From: Paul Cann
Sent: 10 October 2017 09:40
To: Planning.Responses
Subject: RE: Planning Consultation on: AL/106/17/HH

APPLICATION **AL/106/17/HH**

Site Address: Greenfields Farm Fontwell Avenue Eastergate PO20 3RU

Description of Works: Siting of 1 No. mobile home.

Ordnance Survey (c) Crown Copyright 2017. All rights reserved. Licence number 100022432
PROPOSED SITE BLOCK PLAN
SCALE: 1:500

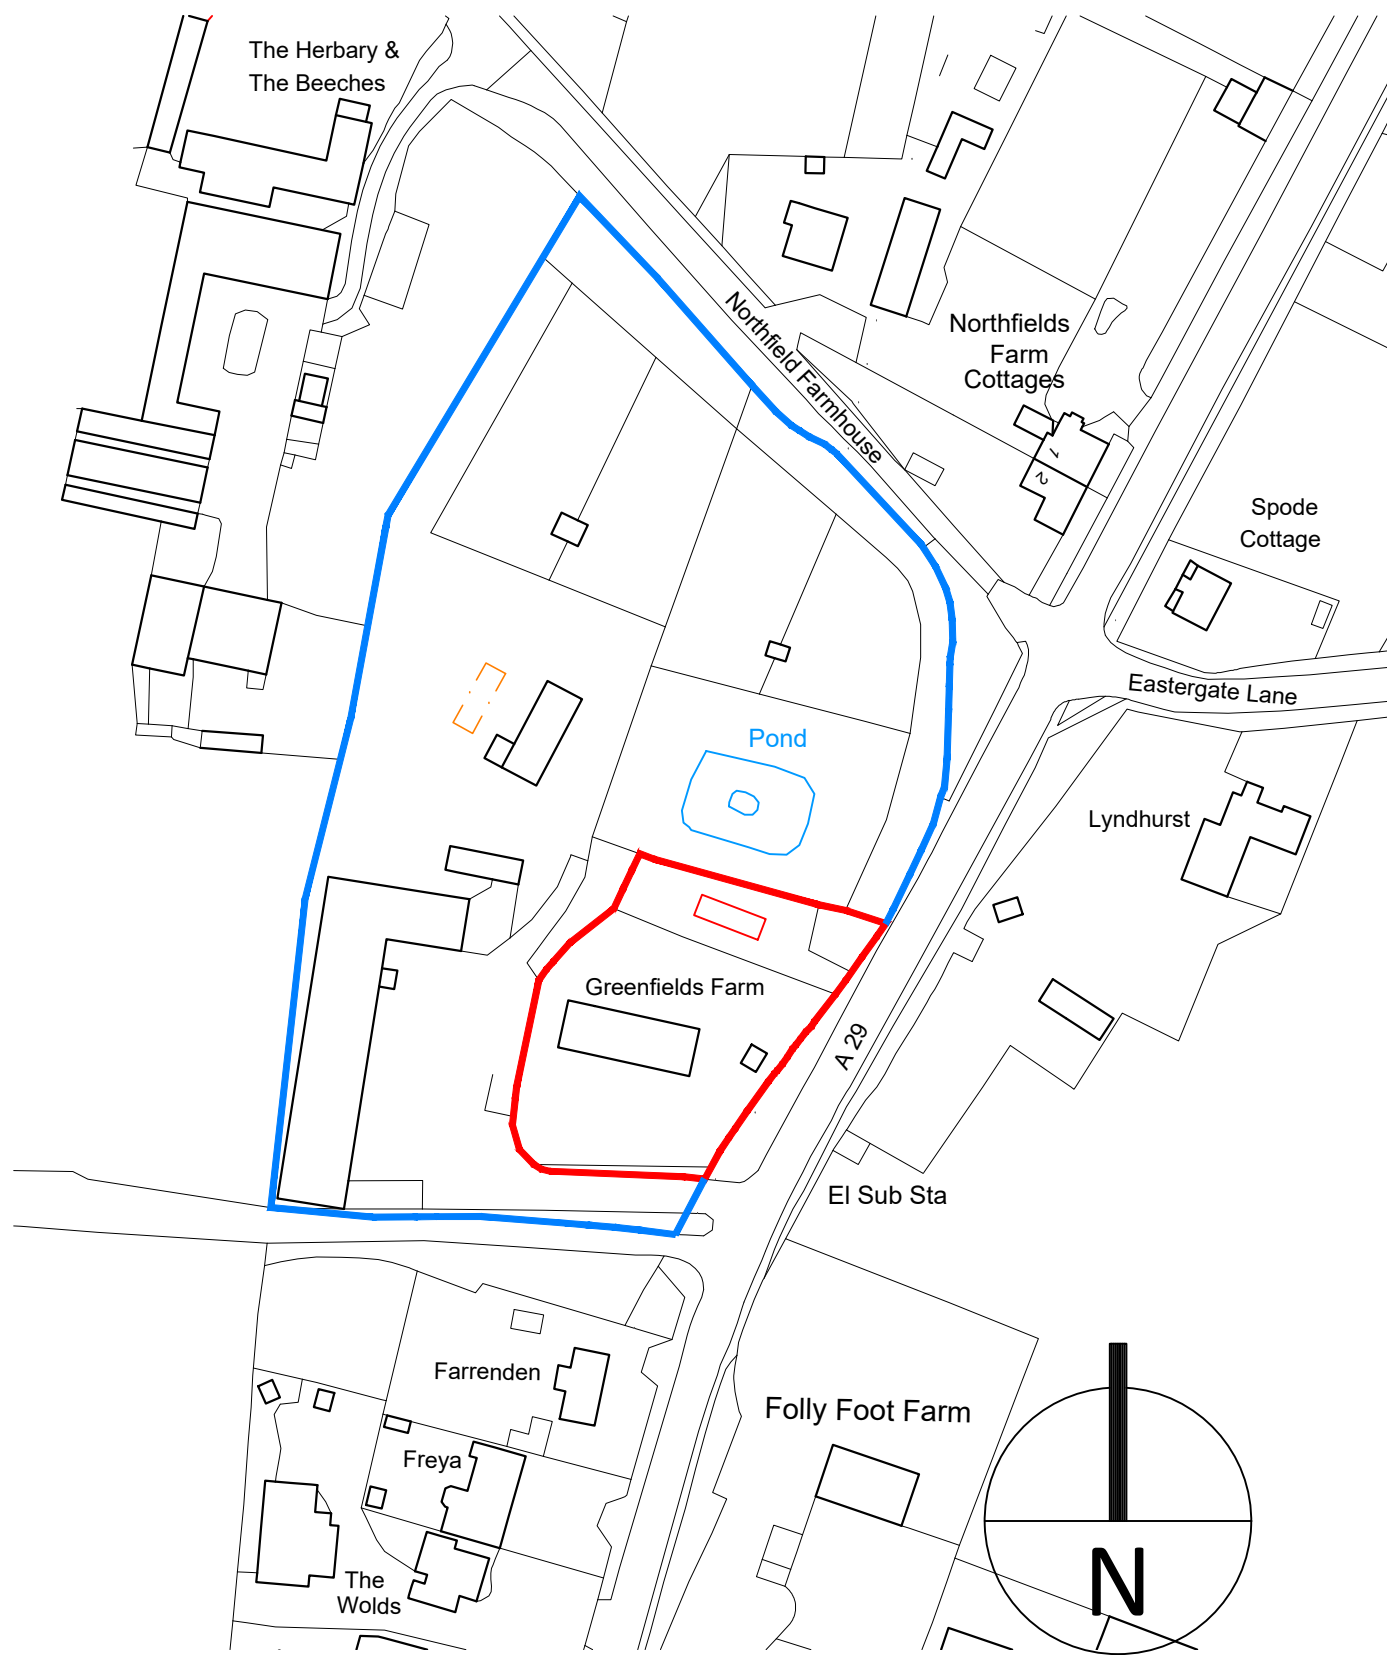
A public foul sewer crosses the site and therefore Southern Water should be consulted.
